Date: 04-Feb-2026
Our Ref: 2025/93455

**Application for a non-material amendment following a grant of planning permission,
Town and Country Planning Act 1990**

Non material amendment to previous permission 2024/92553 for erection of mixed industrial development (Use Classes E(g)(ii, iii), B2 and B8); including demolition of existing structures, new yard, parking, landscaping, drainage features and ancillary structures

**Wappy Springs Inn, Lindley Moor Road, Lindley Moor, Huddersfield, HD3 3TD
Application Number: 2025/93455**

UNITS 9 TO 15
BUILDING PLANS

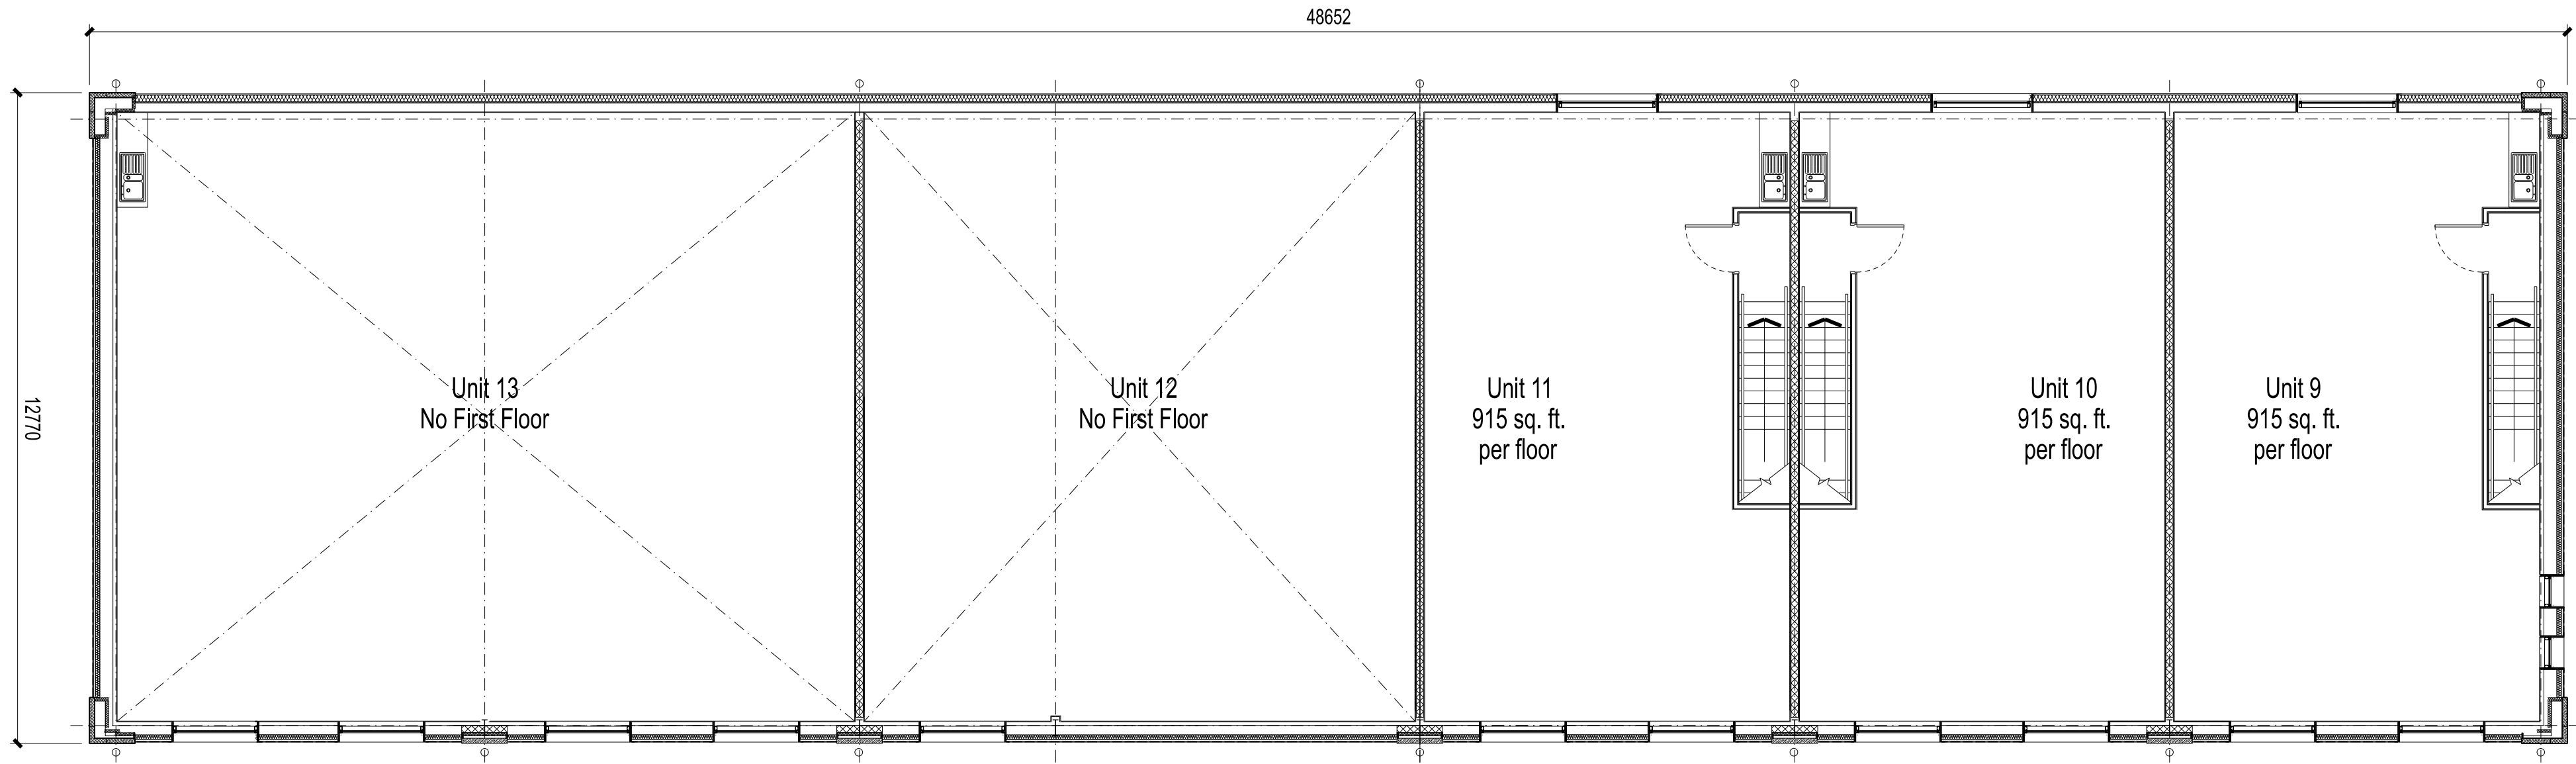
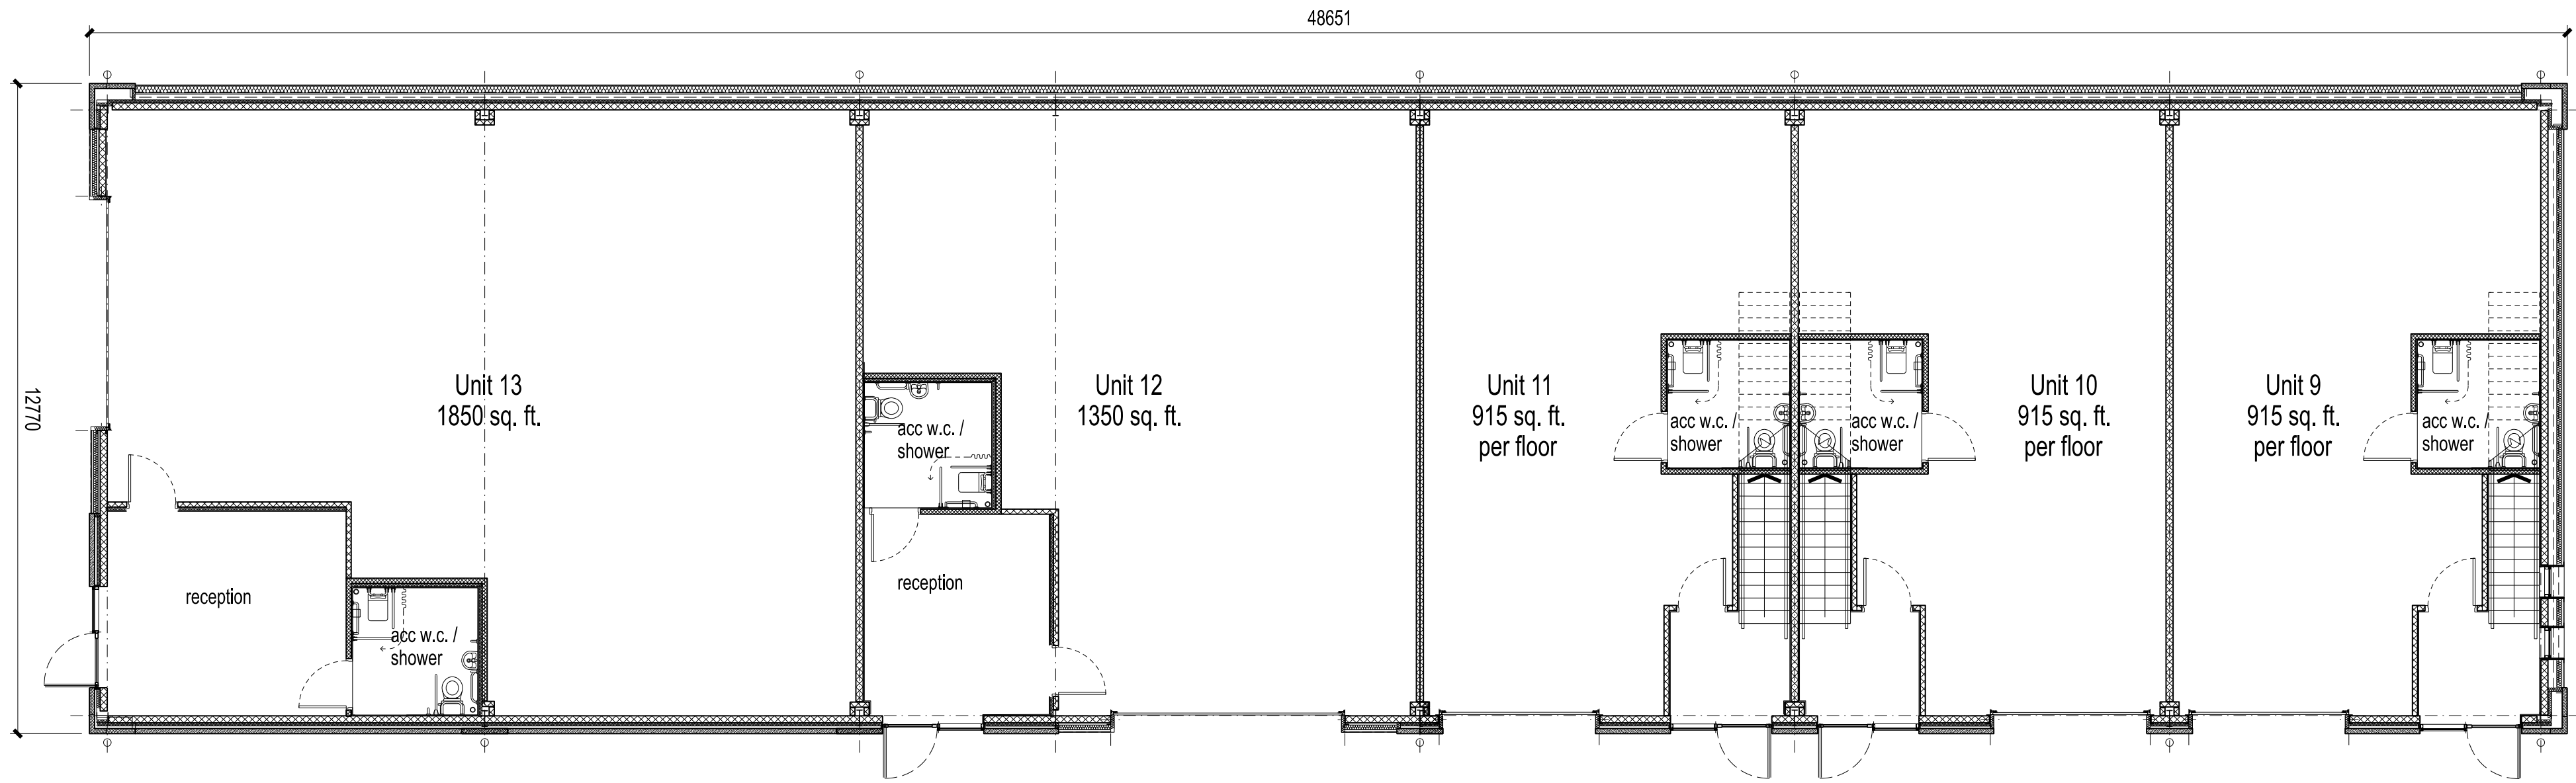
Reconfiguration of the approved layout of the south-western block (units 9-14) to include:

- Removal of unit 14 (previously approved at 125 sqm) and redistribute the floor space
- Redistribution of floor space to increase ground floor space of unit 12 from 85 sqm to 127 sqm
- Redistribution of floor space to increase ground floor space of unit 13 from 85 sqm to 172 sqm
- Removal of upper floor to units 12 and 13
- Reconfiguration of parking layout and external works

The proposed amendments are considered acceptable.

UNITS 9 - 15 ELEVATIONS

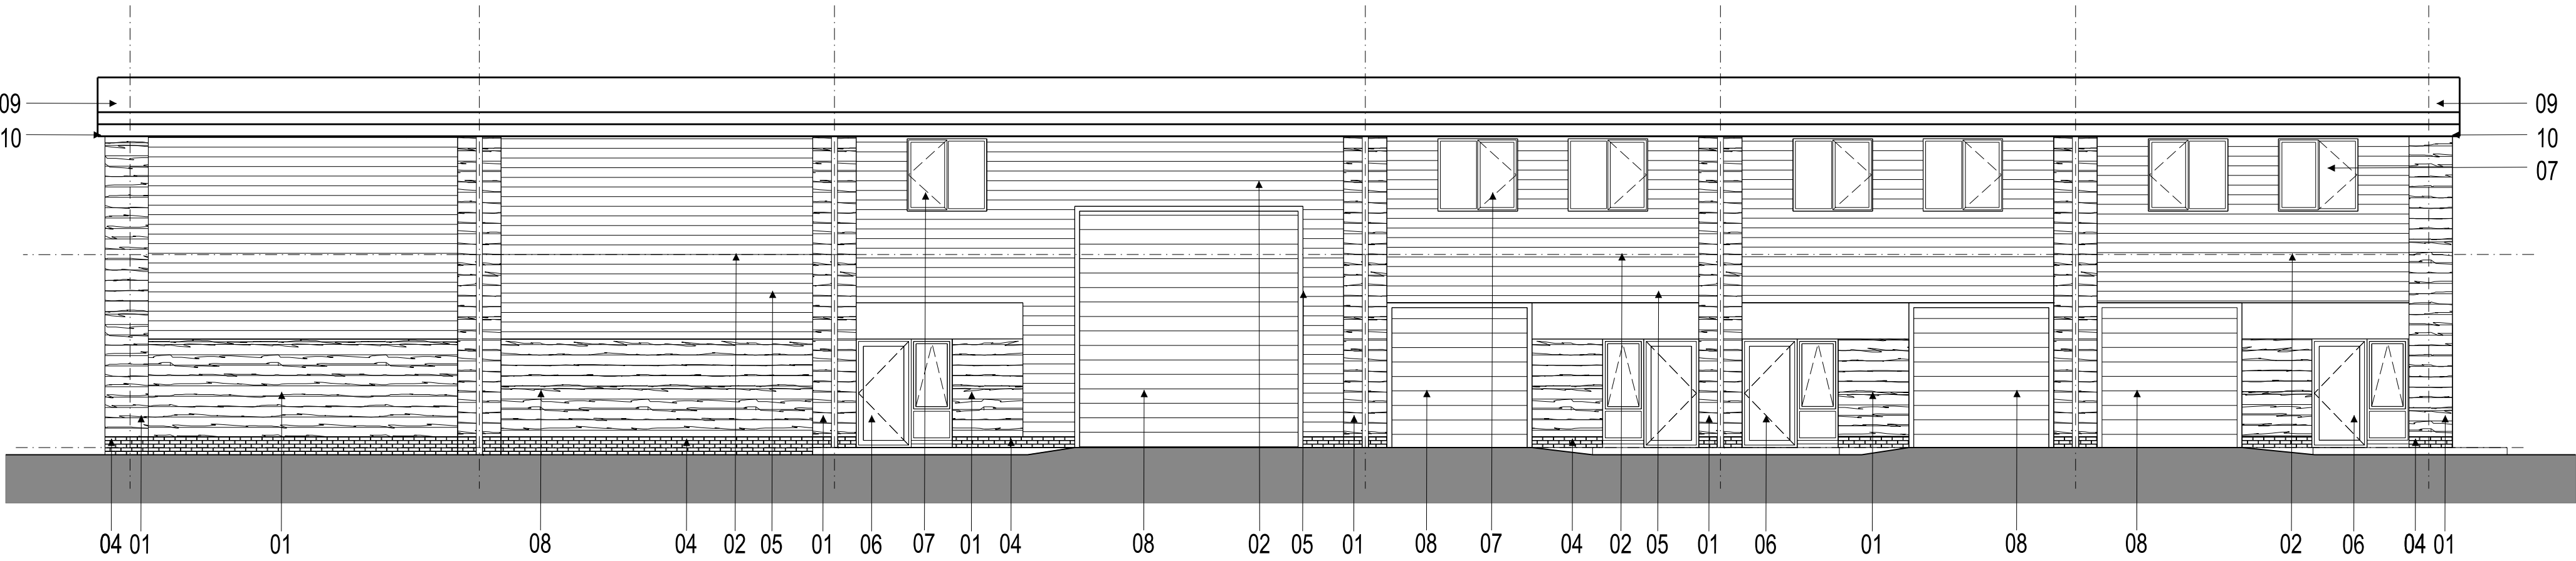
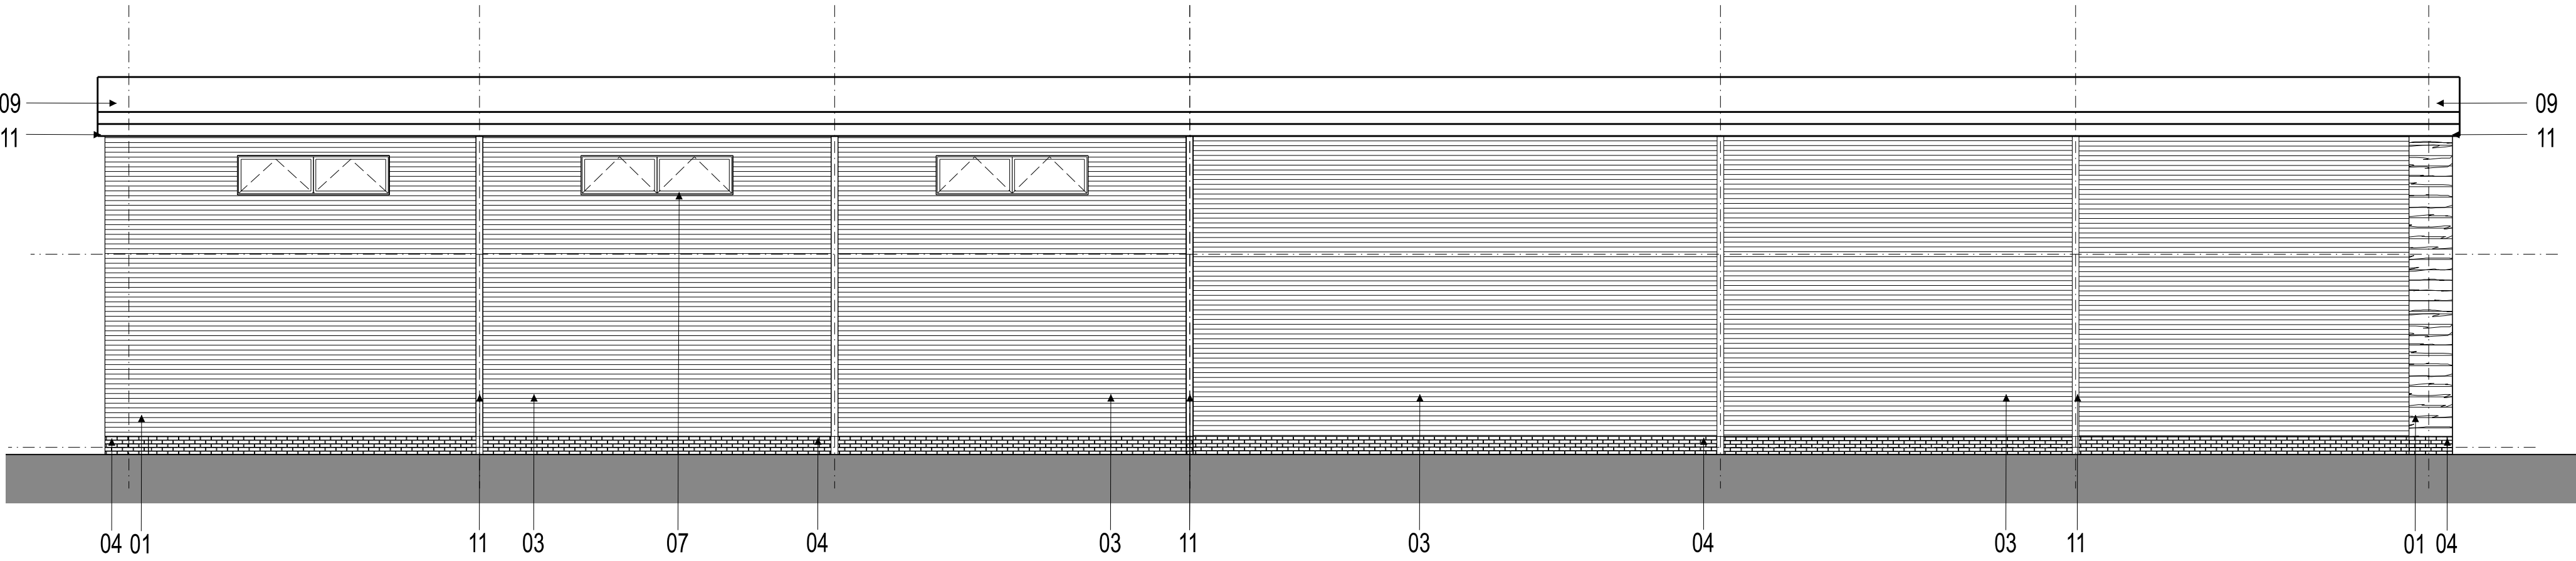
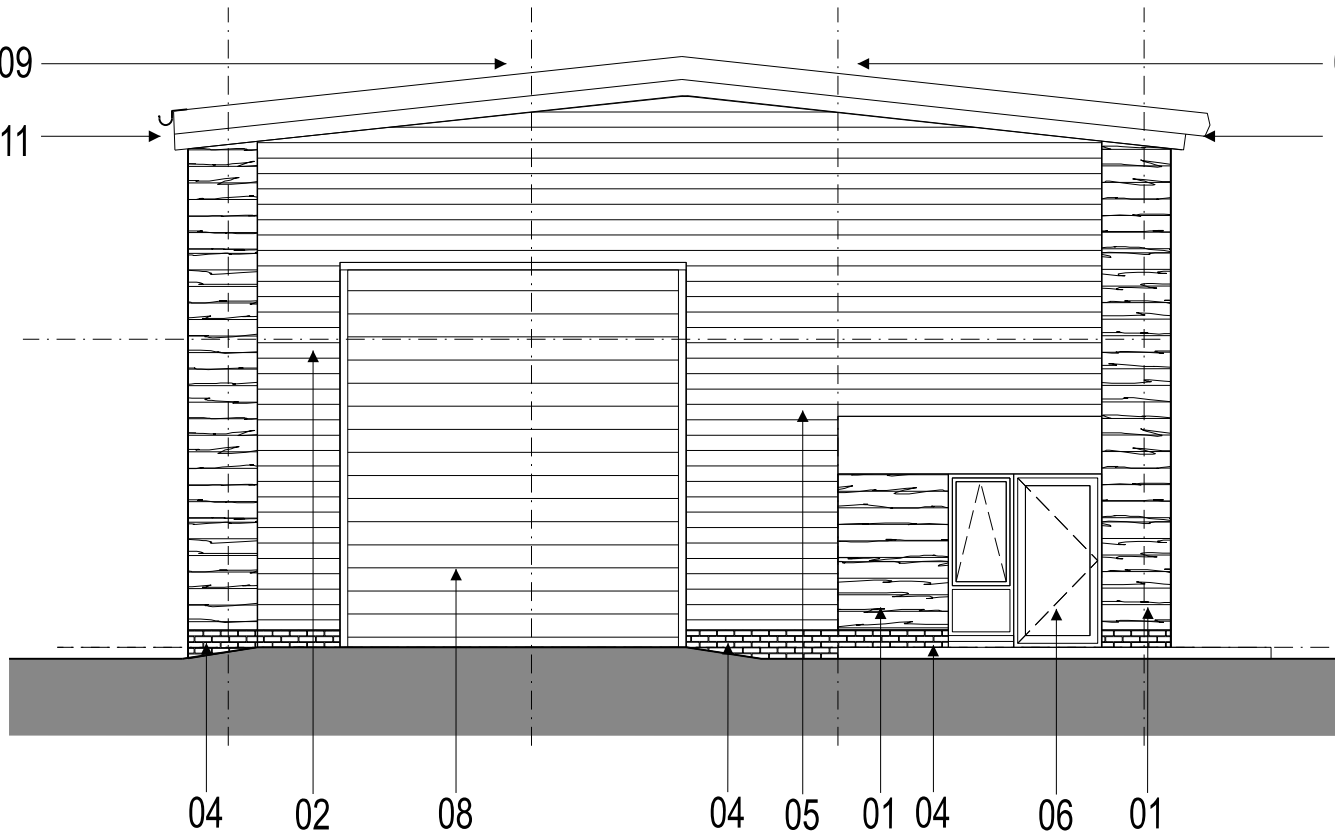
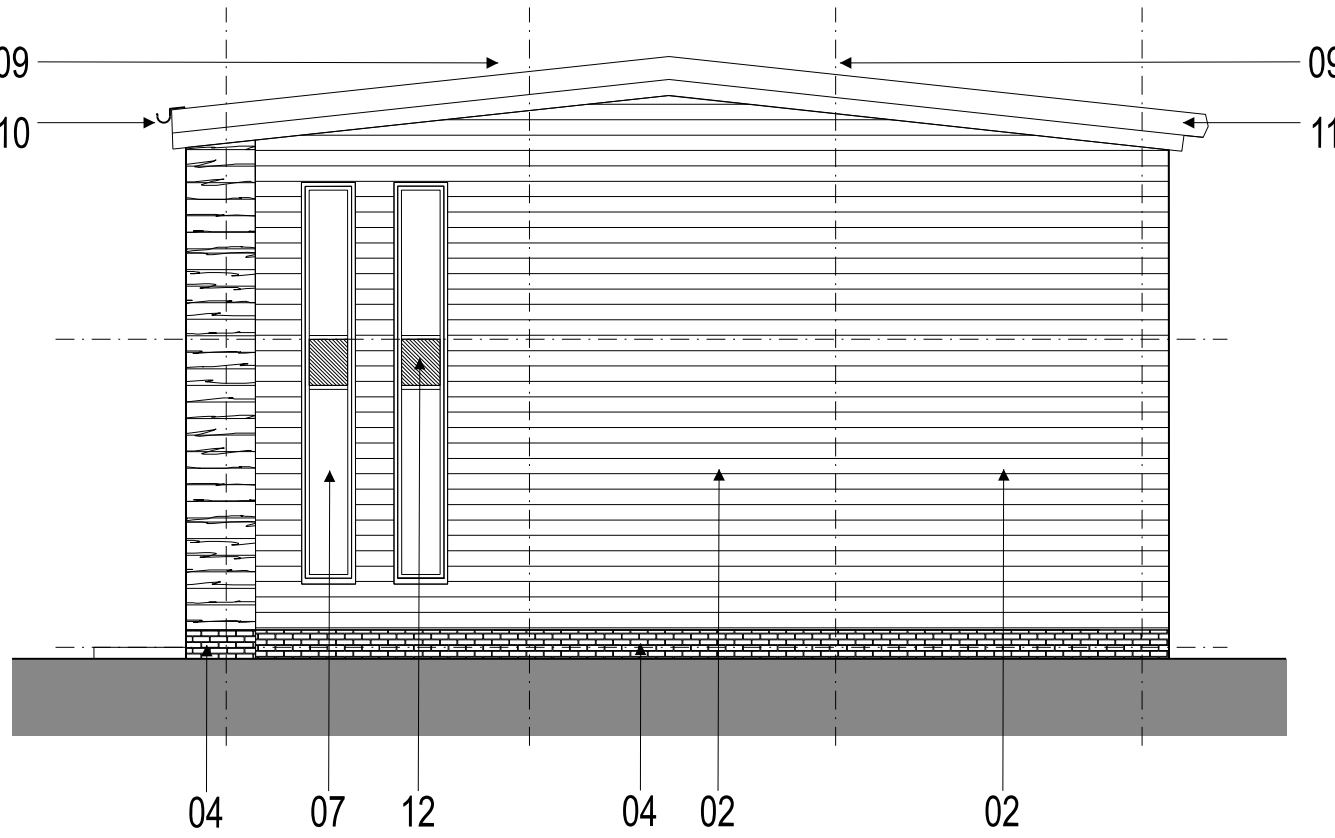
Amendments to the approved elevations of the south-western block including:

- Removal of window openings to the front elevation
- Addition of large overhead door to the front elevation to serve reconfigured unit 12

- Repositioning of door opening and windows, and addition of large overhead door opening to side elevation to serve reconfigured unit 13
